**KIRKLEES METROPOLITAN COUNCIL
DEVELOPMENT & MASTER PLANNING SERVICE**

**DELEGATED DECISION FOR PRIOR APPROVAL FOR CHANGE OF USE
FROM COMMERCIAL, BUSINESS AND SERVICE USES TO
DWELLINGHOUSES**

Reference no. 2025/CL/90833/E

**Site Address 37, Bradford Road/ 2 & 4 King
Street, Cleckheaton, BD19 3JN**

EXISTING ELEVATIONS Scale 1.100

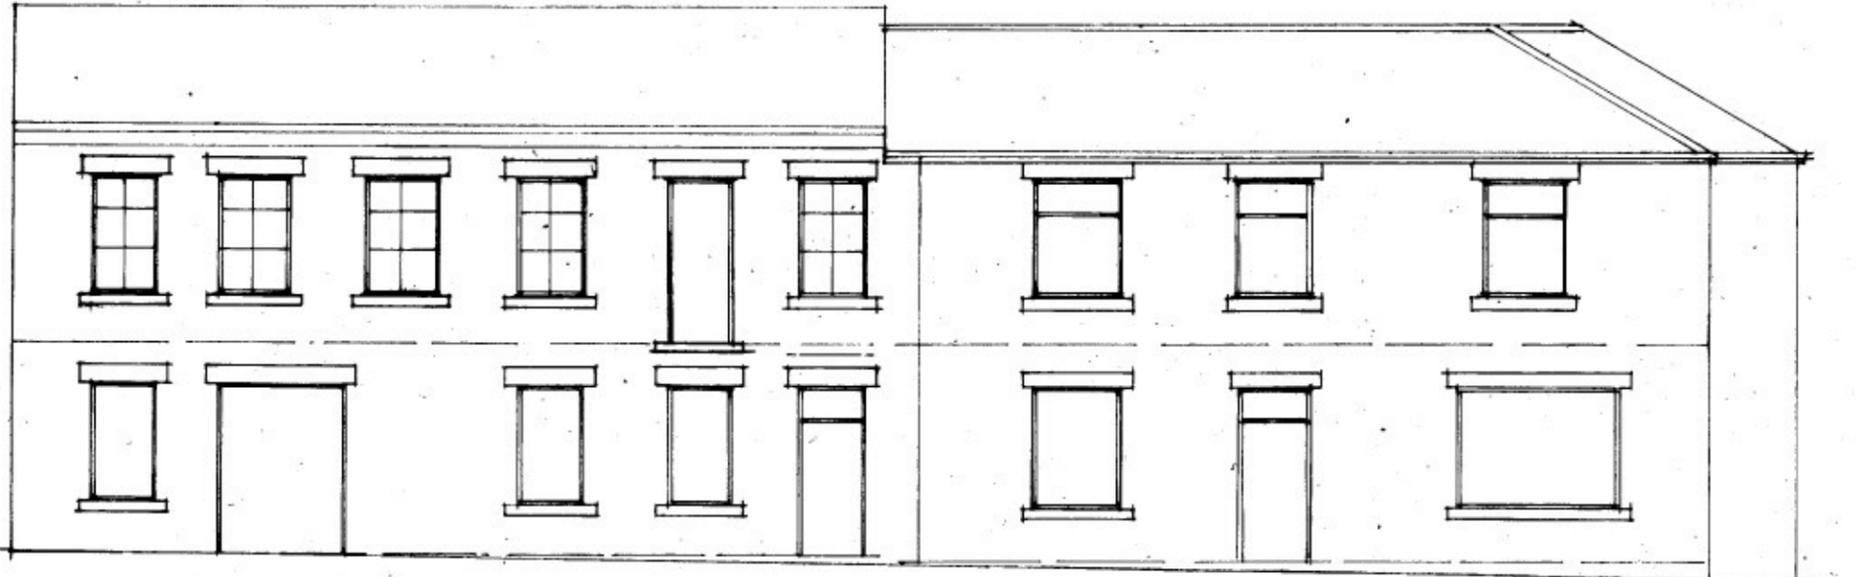
At first floor Unit 7, and at ground floor, Unit 2, would be positioned approximately 5.5m from the site elevation of No.35 Bradford Road/ 1 King Street, a substantial neighbouring building of a part one, two and three storey height. Due to the scale and proximity of this building, the habitable room windows of these unit would experience a significant restriction in access to natural light, particularly given their alignment along the southern façade.

PROPOSED PLANS Scale 1.100

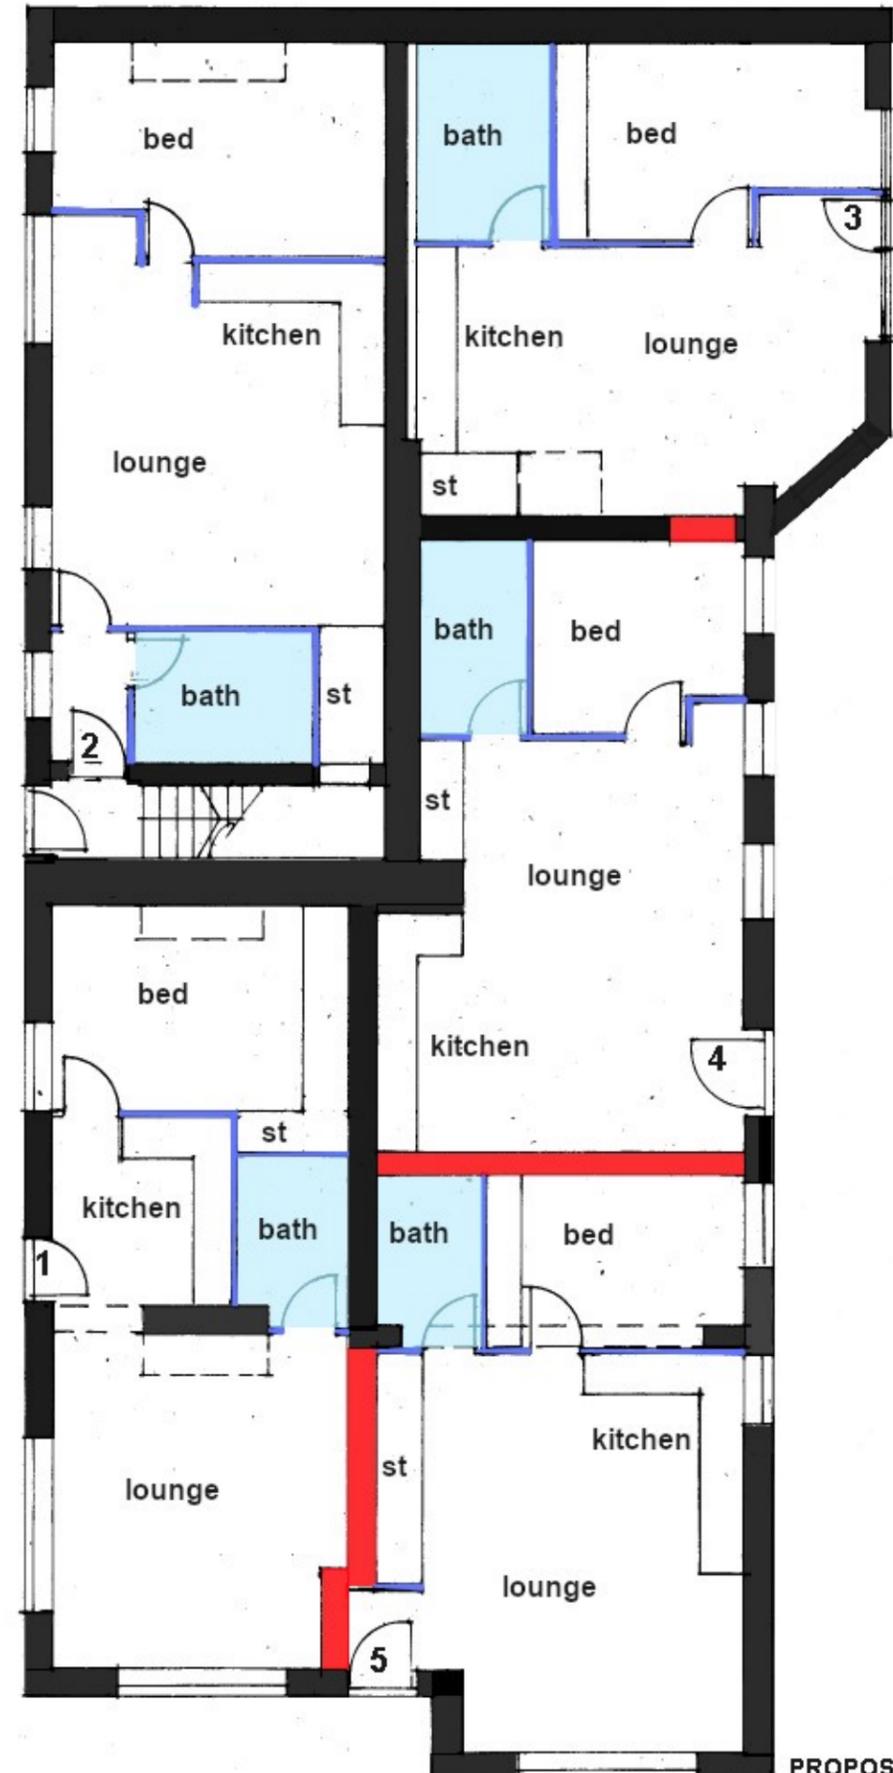
Proposed Units 2, 3, 7, 8 and 9 would all be single aspect, whereas Units 1 and 5, along with the existing flat (unit 6), would be dual aspect. All proposed flats would include habitable rooms served by windows. However, the development fails to demonstrate that adequate natural light would be provided to a number of habitable rooms within the proposal.

Unit 3 would similarly be affected by the adjacent garage/car wash building to the north, which is approximately 1.5 storeys in height with a pitched roof and located around 5m from the proposed habitable room windows. These windows

are small and offer limited glazed area, coupled with their position would result in an inadequate light provision.

No daylight and sunlight assessment or 25-degree line test drawings (as per the Building Research Establishment (BRE) guidance) have been submitted to demonstrate that each habitable room would be afforded an acceptable natural light provision. In the absence of such evidence, and based on the siting, orientation and physical constraints of the site, the proposal fails to demonstrate that adequate natural light would be provided to all habitable rooms, contrary to the requirements of MA.2(2) (f) of the GPDO.

1. The development fails to demonstrate that all habitable rooms within the proposed dwellings would receive adequate natural light, as required under Paragraph MA.2.2(f) of Part 3, Schedule 2 of the Town and Country Planning (General Permitted Development) (England) Order 2015 (as amended). Habitable rooms on the south elevation would face, in close proximity, to a three storey building. The applicant has not demonstrated that both direct and ambient light would not be reduced to an unacceptable level.
